From: Michael Eastham <Michael.Eastham@arun.gov.uk>
Sent: 15 September 2020 11:49
To: Planning.Responses <Planning.Responses@arun.gov.uk>
Subject: FW: BN/84/20/PL - Yapton Road, Barham - Section 73 Layout

Please upload onto Ocella the email below which is a further consultation response from **ADC Drainage Engineers** to Section 73 application **BN/84/20/PL** relating to Angels Nursery, Yapton Road, Barnham.

I have reviewed the information you have provided and have the following initial comments:

LANDSCAPE MASTERPLAN

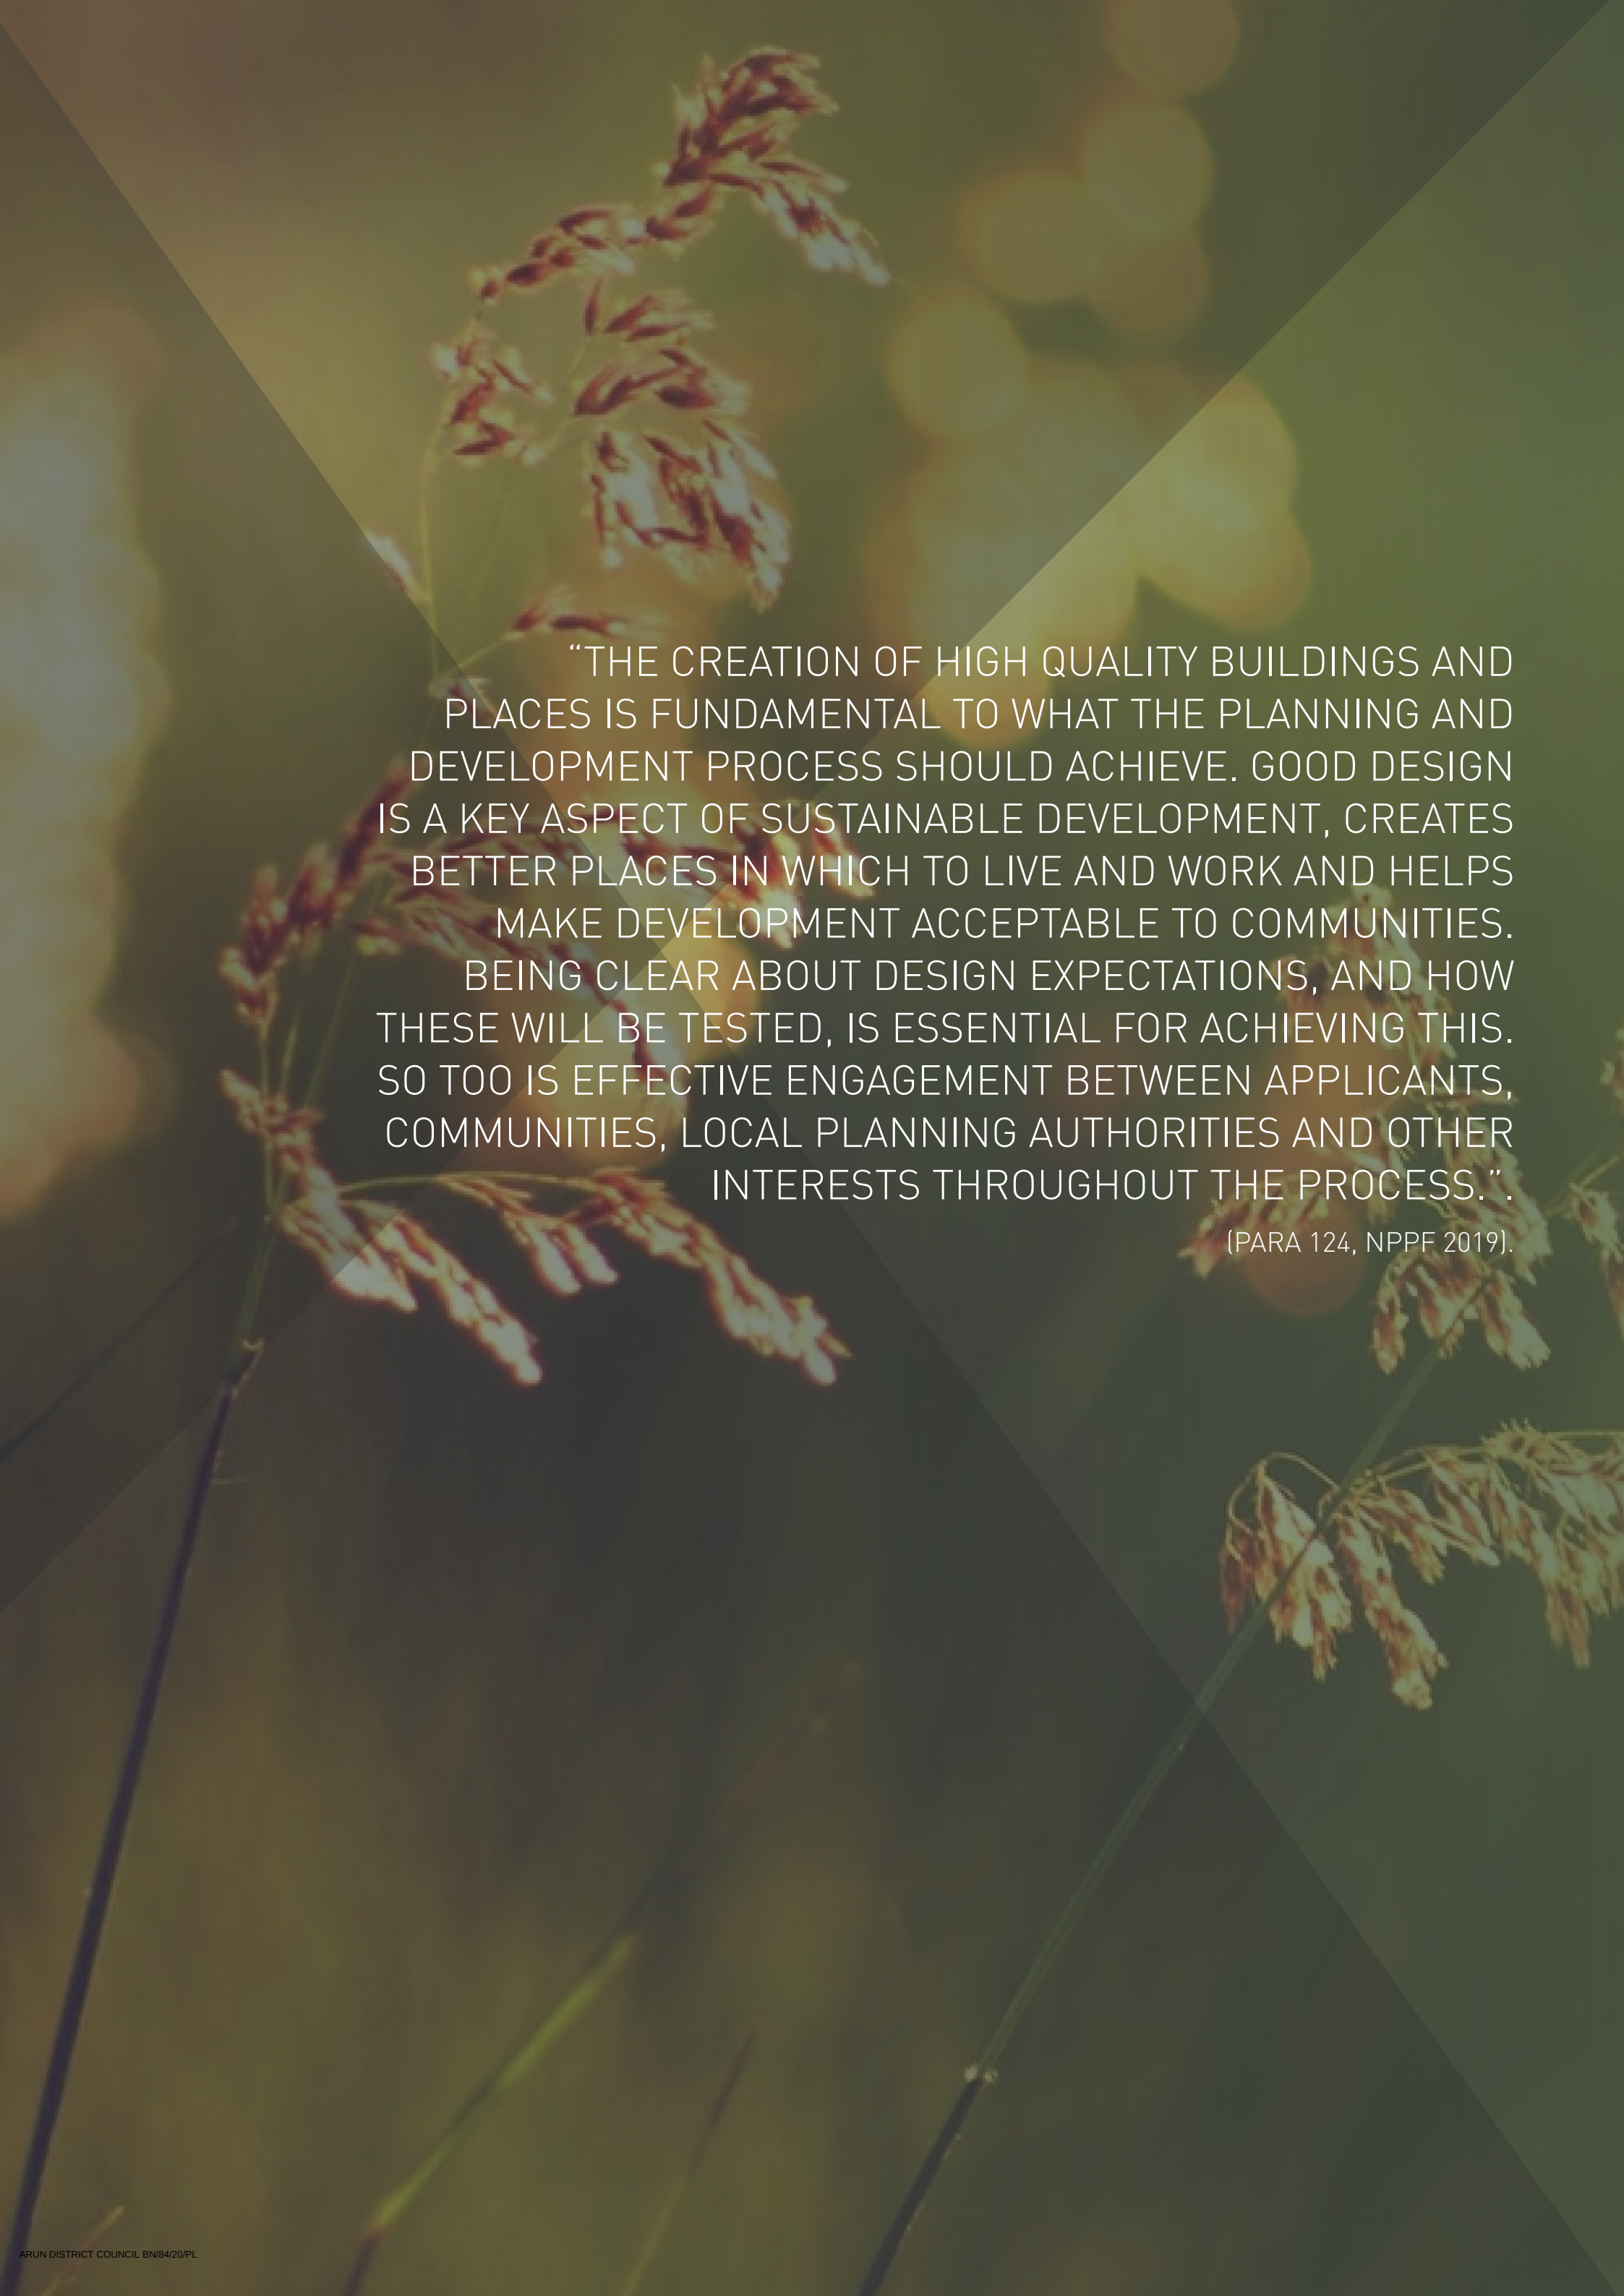
16. The trees indicated on the drainage plans do not tally with those shown on the landscaping plans. No trees should be located over/ within the pond or tank area.
